COUNTY COUNCIL'S RESPONSE TO CONSULTATION ON THE FOLLOWING DEVELOPMENT PROPOSAL

Application No: 20/03694/REM

Proposal: Variation of condition 1 (plans) of 19/00895/REM - to incorporate amendments to plots within the range 184 - 280

Location: OS Parcels 6741 And 5426 West Cricket Field North Wykham Lane Bodicote

Drawing Title LANDSCAPE PROPOSALS (SHEET 1 OF 6)			
Scale 1:200	Sheet Size A1	Date JAN 2021	
Client Ref. -	Drawing Ref. 2933-5-2	Drawing No. DR-5001	Status S4-P1

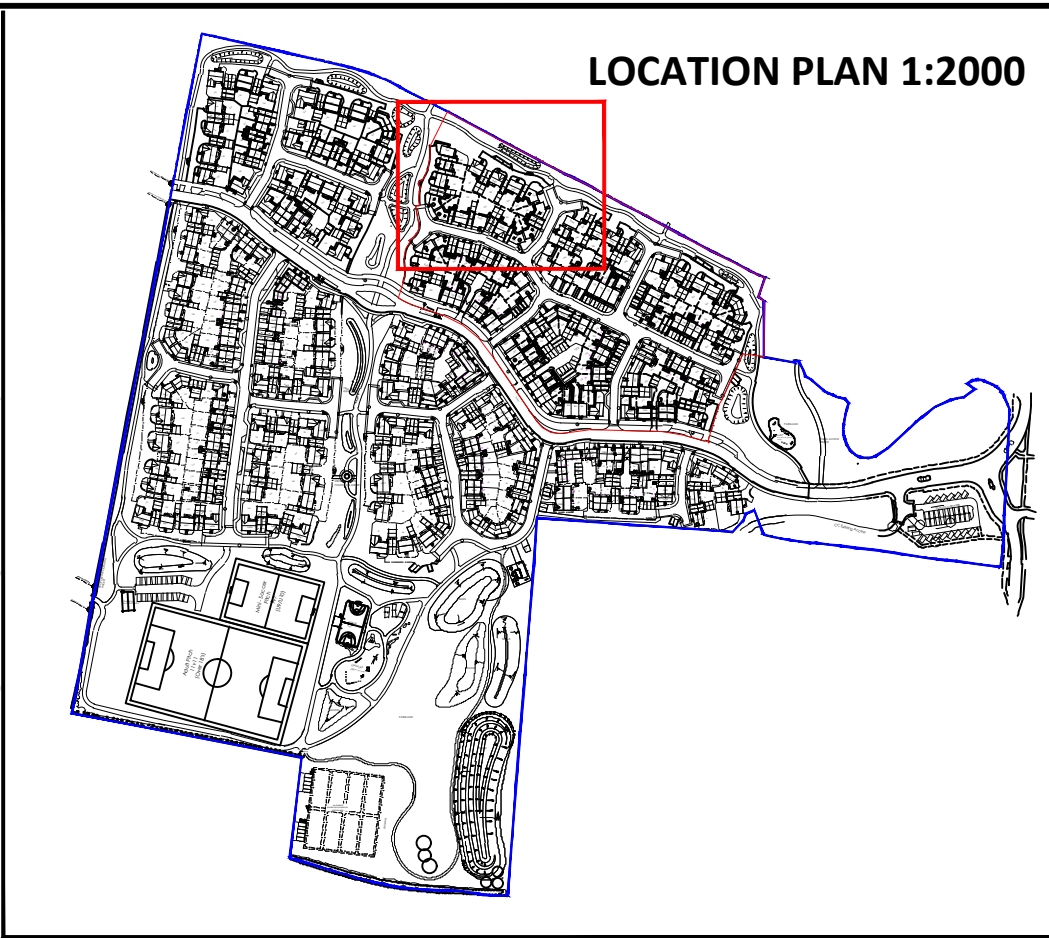
The overall layout is deemed acceptable subject to a tracking exercise that should cover the revised rear parking court serving plots 219-229. To the right, beyond the row of 4 perpendicular bays fronting the carport are two parking spaces (serving plots 229) that appear to be aligned in a way whose access may be compromised in the event that the spaces either side are occupied. It may be that a slight shift away from the first 4 spaces is required to address this. *See snippet below.*

While the aisle space is noted to slightly be under the required 6m depth, I am inclined to assume access to either bays is possible but needs to be accompanied by a vehicle tracking exercise.

Prior to the commencement of the development hereby approved, and notwithstanding the application details, full tracking details of a large size car turning within the parking bays serving plot 229 shall be submitted to and approved in writing by the Local Planning Authority. Thereafter, the development shall be carried out in accordance with the approved details.
